Town & Country Planning Act 1990 (as amended)
Town and Country Planning (Development Management Procedure) (England) Order 2015
Approval of details reserved by condition imposed under BR/306/16/PL relating to conditions 3-
surface water drainage, 5-landscape scheme, 6-schedule of materials & finishes, 8-refuse &
recycling bin enclosure & 9-covered & secure cycle parking spaces.
10-12 Land At Devonshire Road, Bognor Regis,

Arun District Council have decided to **REFUSE details reserved by condition for the following reasons:**

TITLE:
PROPOSED DRAINAGE STRATEGY

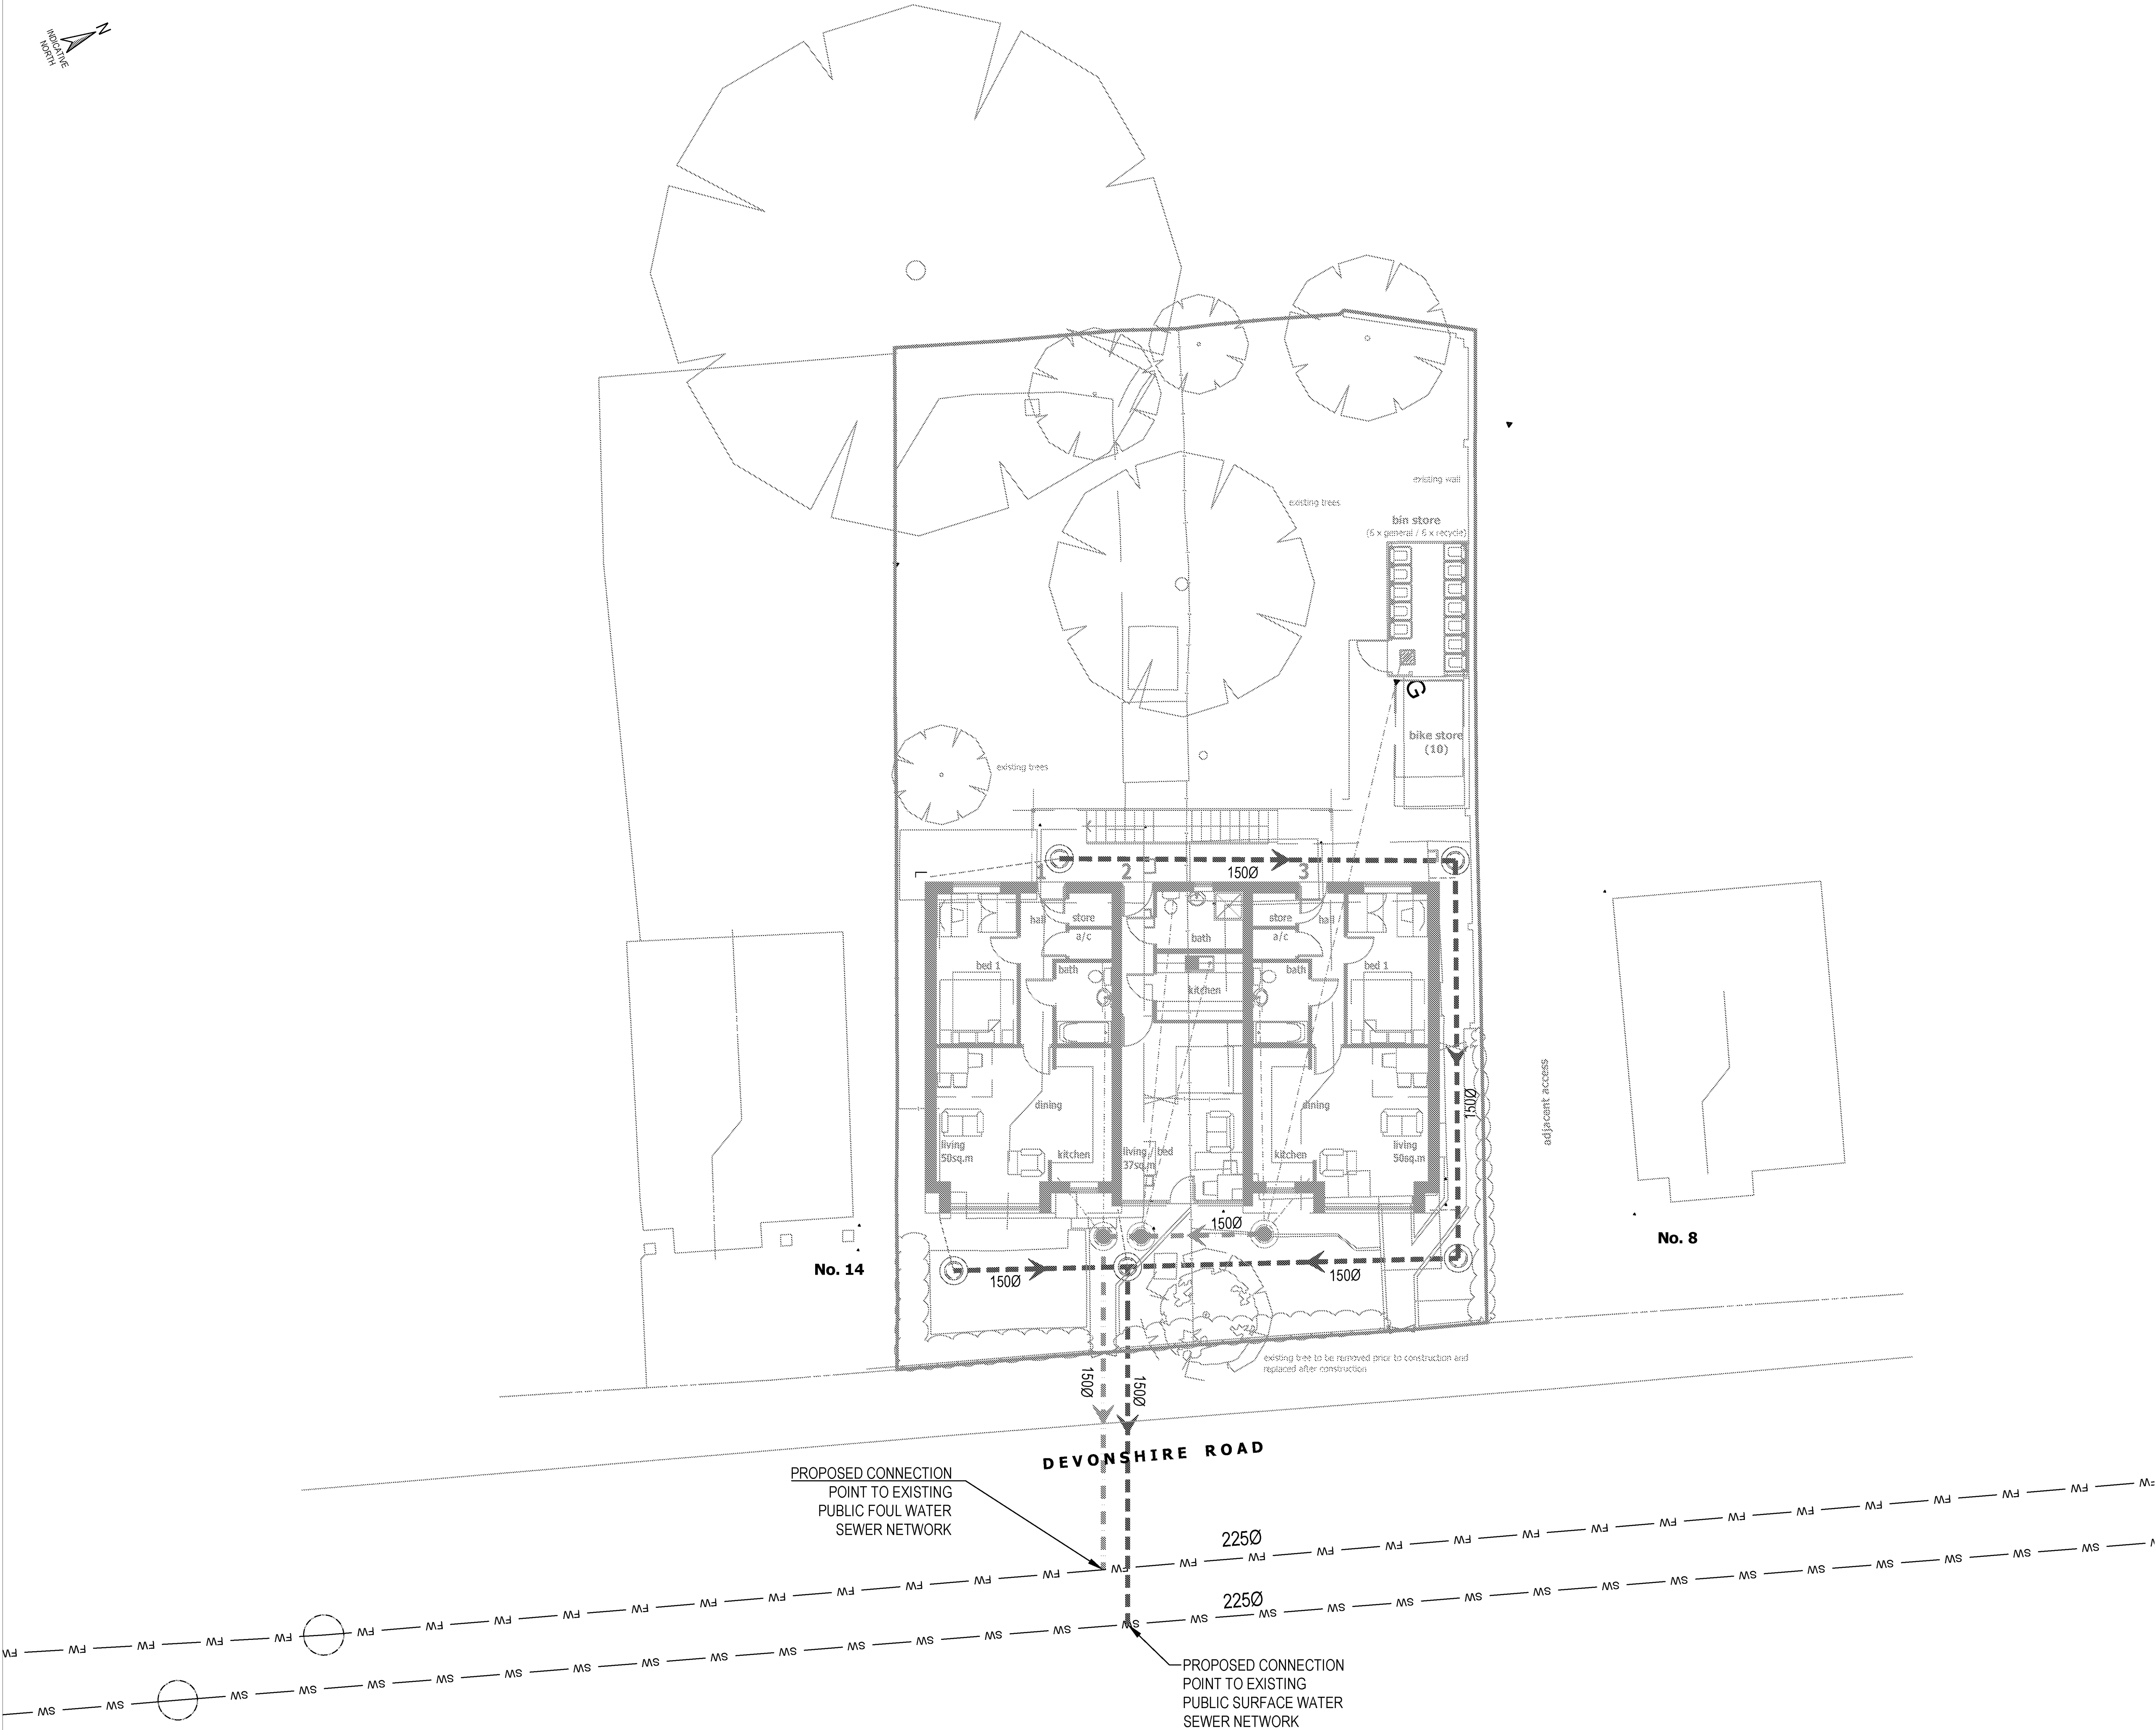
"The proposal is to dispose of surface water into the surface water sewer in-attenuated as a result of exceptionally high groundwater levels encountered on site. In order for us to discharge this condition we require proof that southern water are happy with this proposal, i.e. docdeci

S106 and capacity check. It would be useful to understand how the previous buildings disposed of their surface water and if this was into the surface water why new connections are proposed. All areas of paving should be permeable paving as these are not currently included within the drainage proposals and would otherwise increase runoff. The drainage layout plan should be updated to show locations of catchpits, invert levels, cover levels and fall of pipes. Please also provide construction detail drawings of manholes, pipe protection details and catchpits.
